Submission No.			269	
Organisation Name or Name of Submitter			Roisin Shortall	
Item No.	Section Ref.	Page No.	Observation Statement	TII Response
Letter Re 314724: MetroLink Railway Order Submission 16th January 2023				
1	Intro	1	<p>From the outset, I must state that I am in favour of the MetroLink project. The North-West of Dublin has, for many years, been overlooked in the allocation of public transport resources. There have been a number of very disappointing false dawns relating to the Metro in the past and it is understandable that people in the area are sceptical that the project will be delivered. It is therefore essential the Government honours its commitment to the project. It is also essential that TII and the NTA work closely with the community to build a level of trust to provide clear and transparent responses to queries raised, respond speedily to problems when they arise and thereby seek to ensure local ‘buy in’.</p> <p>While I welcome the publishing of the Railway Order of the Metrolink, there are a number of issues and concerns over some aspects of the project in the Dublin North-West Constituency.</p> <p>I will outline these concerns and questions below.</p>	<p>M

COLLINS AVENUE STATION

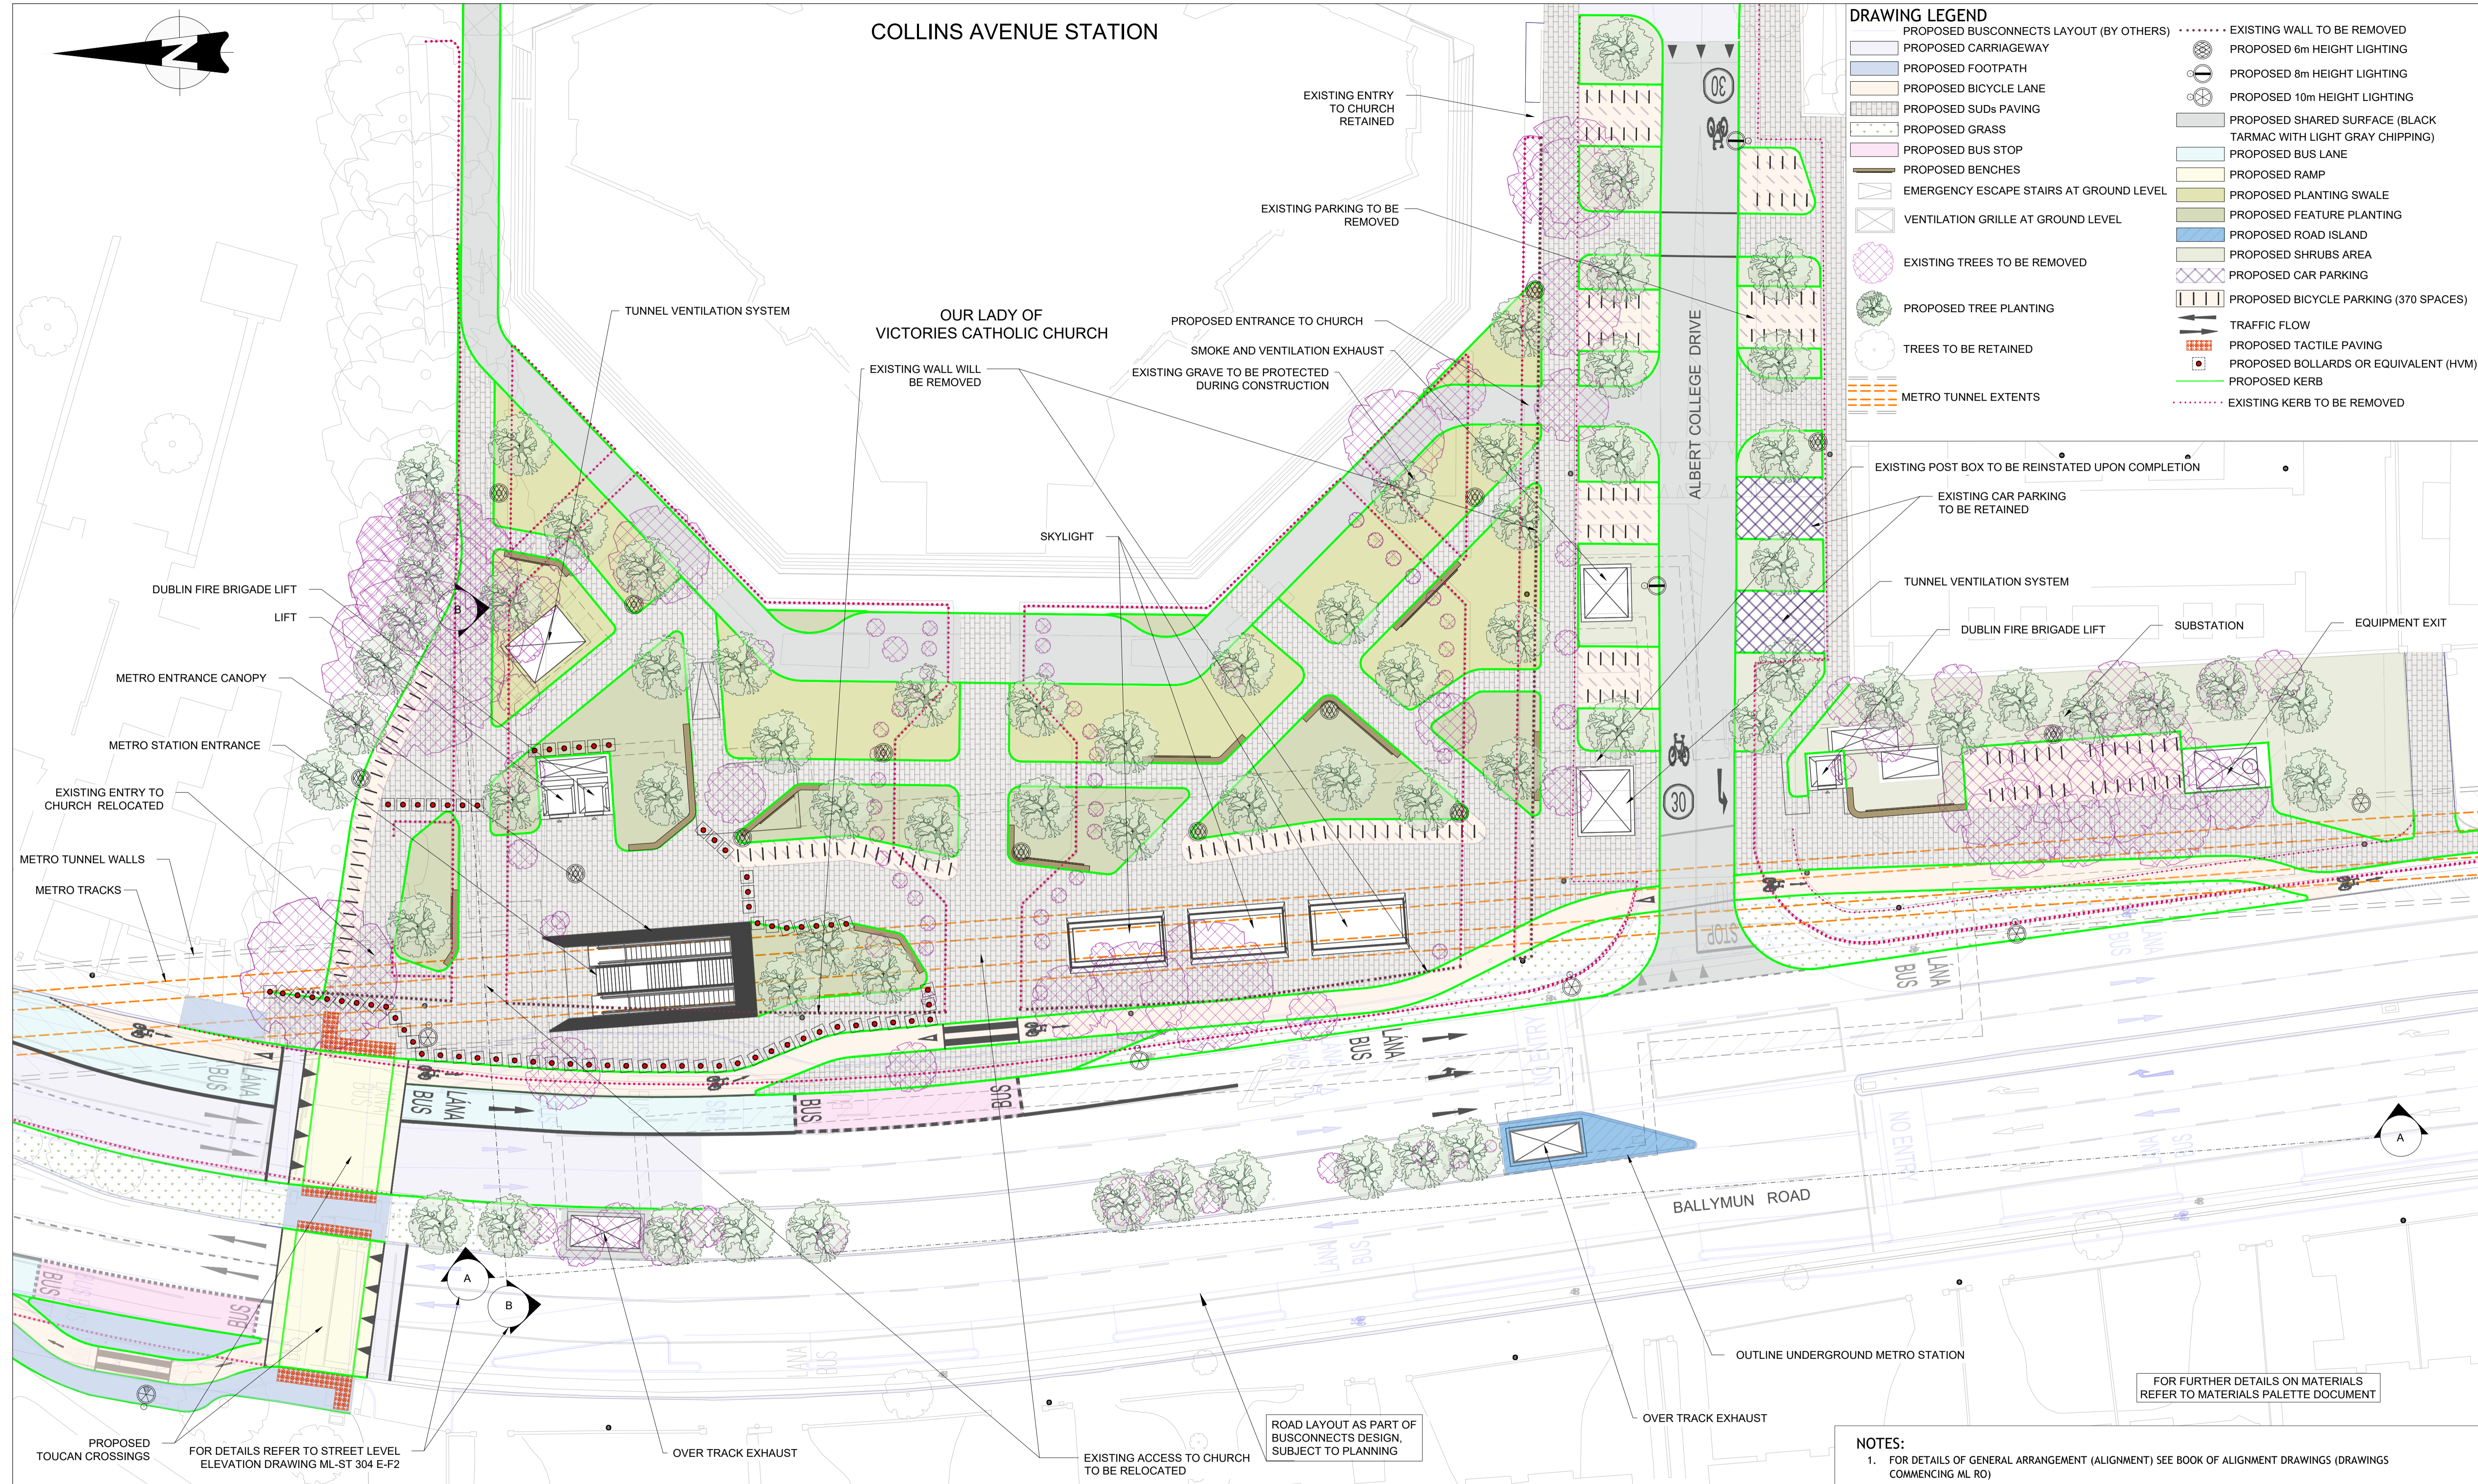
8	Rationale for Selection of Station Locations	2	The proposed location of the Collins’ Ave station and the associated Intervention Shaft in Albert College Park has caused concern among some residents in the Dublin North-West Constituency. In the original Metro North project, there were plans for a Metro station to be placed in Albert College Park. In the current MetroLink Railway Order, the closest station to Albert College Park is the Collins Avenue station, necessitating an Intervention Shaft located in the southwest corner of the park. Some residents have been querying why the original location of the Metro station in Albert College Park was abandoned. What was the rationale for selecting Collins Avenue as the location for the Metro Station?	<p>As outlined in section 7.7.10.7 of Chapter 7 of the EIAR, the assessment undertaken for the Emerging Preferred Route (EPR) identified a preferred route option including the proposed station location in front of Our Lady of Victories Church.</p> <p>This location for the station provides a number of advantages when compared to other location options: (1) It allows the project to achieve a core project objective of providing public transport that is integrated in the existing and future proposed transport network, providing for interchange between bus routes both on Collins Avenue and on Glasnevin Road. A station location further south at the northern section of Albert College Park would not provide a good level of interchange as there would be over 500m separating potential bus stop locations on Collins Ave and the MetroLink station. (2) The proposed Collins Avenue Station will have a significant catchment area, noting the analysis undertaken at the Emerging Preferred Route (EPR) stage identified this route option had the highest potential passenger numbers when compared with other route options. (3) During the construction phase, the location of a station within the frontage to Our Lady of Victories means that traffic disruption to Dublin would be reduced when compared to the location of a station within the road corridor (partially or fully).</p> <p>The predicted temporary environmental impacts during construction on the surrounding area can be mitigated effectively as detailed in the relevant chapters of the EIAR.</p> <p>Once the station is operational, the location of a MetroLink station here will provide significant positive benefits to the local community in terms of enhanced public transport provision, reduced traffic and the resultant improvements in the environment as a result of reduced noise and air quality pollution.</p>

Submission No.			269	
Organisation Name or Name of Submitter			Roisin Shortall	
Item No.	Section Ref.	Page No.	Observation Statement	TII Response
Letter Re 314724: MetroLink Railway Order Submission 16th January 2023				
9	Rationale for Selection of Station Locations	2	-There is local concern that placement of the Metro Station on Collins Avenue, beside Our Ladies of Victory Church, is likely to pose a number of challenges. There are two primary schools located opposite the proposed location of the Collins Avenue Station: Our Lady of Victories Girls School and Our Lady of Victories Boys School. It is feared that the location of the station could pose safety concerns for children accessing the schools as well as difficulty for parents dropping their children off at school as parking spaces will be reduced due to construction works.	<p>Providing MetroLink in a safe manner is critical to the success of the Project. TII will focus on both construction worker safety but also critically on vulnerable road users and the communities within which we will work including the staff and pupils of Our Lady of Victories Girls and Boys Schools and churchgoers.</p> <p>Prior to the enabling works and the main construction phase a Traffic Management Plan will be developed by the contractor (Refer to Appendix A9.5 of the EIAR). The contractor will be legally required to adhere to the requirements of the plan on a day by day basis and so any such measures will be implemented with a focus on managing traffic movements to ensure that there are no accidents. It should also be noted that as outlined in Table 9.64 in Chapter 9 of the EIAR, enabling works in this area will be undertaken such that 1 lane of general traffic and 1 bus lane in each direction will remain open. Dedicated cycle lanes will also be provided during the construction phase. Furthermore, as outlined in EIAR Appendix A9.5 section 2.5.2.2, construction vehicles will be controlled in terms of the hours of operation (i.e. construction traffic will be prohibited during periods of very heavy traffic and during school drop off and pick up periods). Also outlined in EIAR Appendix A9.5 Section 7.4.6.3.6, during both the Advanced Enabling Works and Main Works, the signalised pedestrian/toucan crossing outside of the front of the school will be retained during all works and will continue to allow safe access for pedestrians and vulnerable users. Additionally, there will be controls at the entrance and exits of sites for construction vehicles in order to ensure the safety of other road users.</p>

Submission No.			269	
Organisation Name or Name of Submitter			Roisin Shortall	
Item No.	Section Ref.	Page No.	Observation Statement	TII Response
Letter Re 314724: MetroLink Railway Order Submission 16th January 2023				
11	Rationale for Selection of Station Locations	3	There have been suggestions from residents to move the Collins Avenue Station to Albert College Park, as originally planned in the Metro North project. Given the requirement for an intervention shaft in Albert College Park, it is argued that it would be less disruptive overall to locate a station there rather than at the proposed Collins’ Avenue location. TII should provide their reasoning for locating the station at Collins Avenue and if this is to go ahead, they must work closely with residents to address their concerns and minimise the negative impacts.	Please see above response to Query no. 8
12	Albert College Park Intervention Shaft	3	In the event that the Collins’ Avenue station remains as part of the scheme, we are told that the Intervention Shaft is a necessary part of the project. Its function is to allow emergency services to access the underground system in an emergency situation and to provide a safe route for passengers to escape from the tunnel in the event of an emergency. However, regarding the current plans for the intervention shaft in Albert College Park, it appears that the scale of the structure need not be as large as required. The shaft footprint includes an emergency service parking area, but this could be accommodated outside of the park on the Ballymun Road.	A maintenance access road from the R108 Ballymun Road and associated hardstanding area are provided at the intervention shaft in Albert College Park. An additional emergency exit to the R018 Ballymun Road is also provided to allow for a one-way system as requested by DFB. TII will continue to work with DFB to minimise footprints where possible but currently it is not possible to agree to road side parking. The structure itself is sized to suit operational requirements.

13	Albert College Park Intervention Shaft	3	Furthermore, the sections of the park that are being temporarily acquired under the Railway Order for the relining of the football pitches should only be for the duration of the relining works and not for period of the construction of the Intervention Shaft nor for the placement of spoil. It is imperative that both the community and local sports groups not lose access to these sports pitches for any longer than absolutely necessary.	TII will minimise disruption so far as is reasonably practical and will optimise the occupation timescales during the detailed design phase with the contractor. However, TII acknowledges the impact of the proposed Projects construction phase on the sports pitches at Albert College Park. As noted in Ch11, Table 11.64 Land take required for the Albert College Intervention shaft will result in the loss of both of the existing 5 a-side pitches and a small portion of one of the full-sized pitches which is noted as a negative, significant, short-term effect. However, to maintain the existing facilities, it is proposed to rotate the existing full-sized pitches 90 degrees and locate them side-by-side to the east of the park, resulting in slightly reduced dimensions. Sufficient area will be available to increase the dimensions of both 5 a-side pitches. Sufficient area will also be available for circulation around the pitches while they are occupied. The impacts will be reduced to negative, slight, short-term.
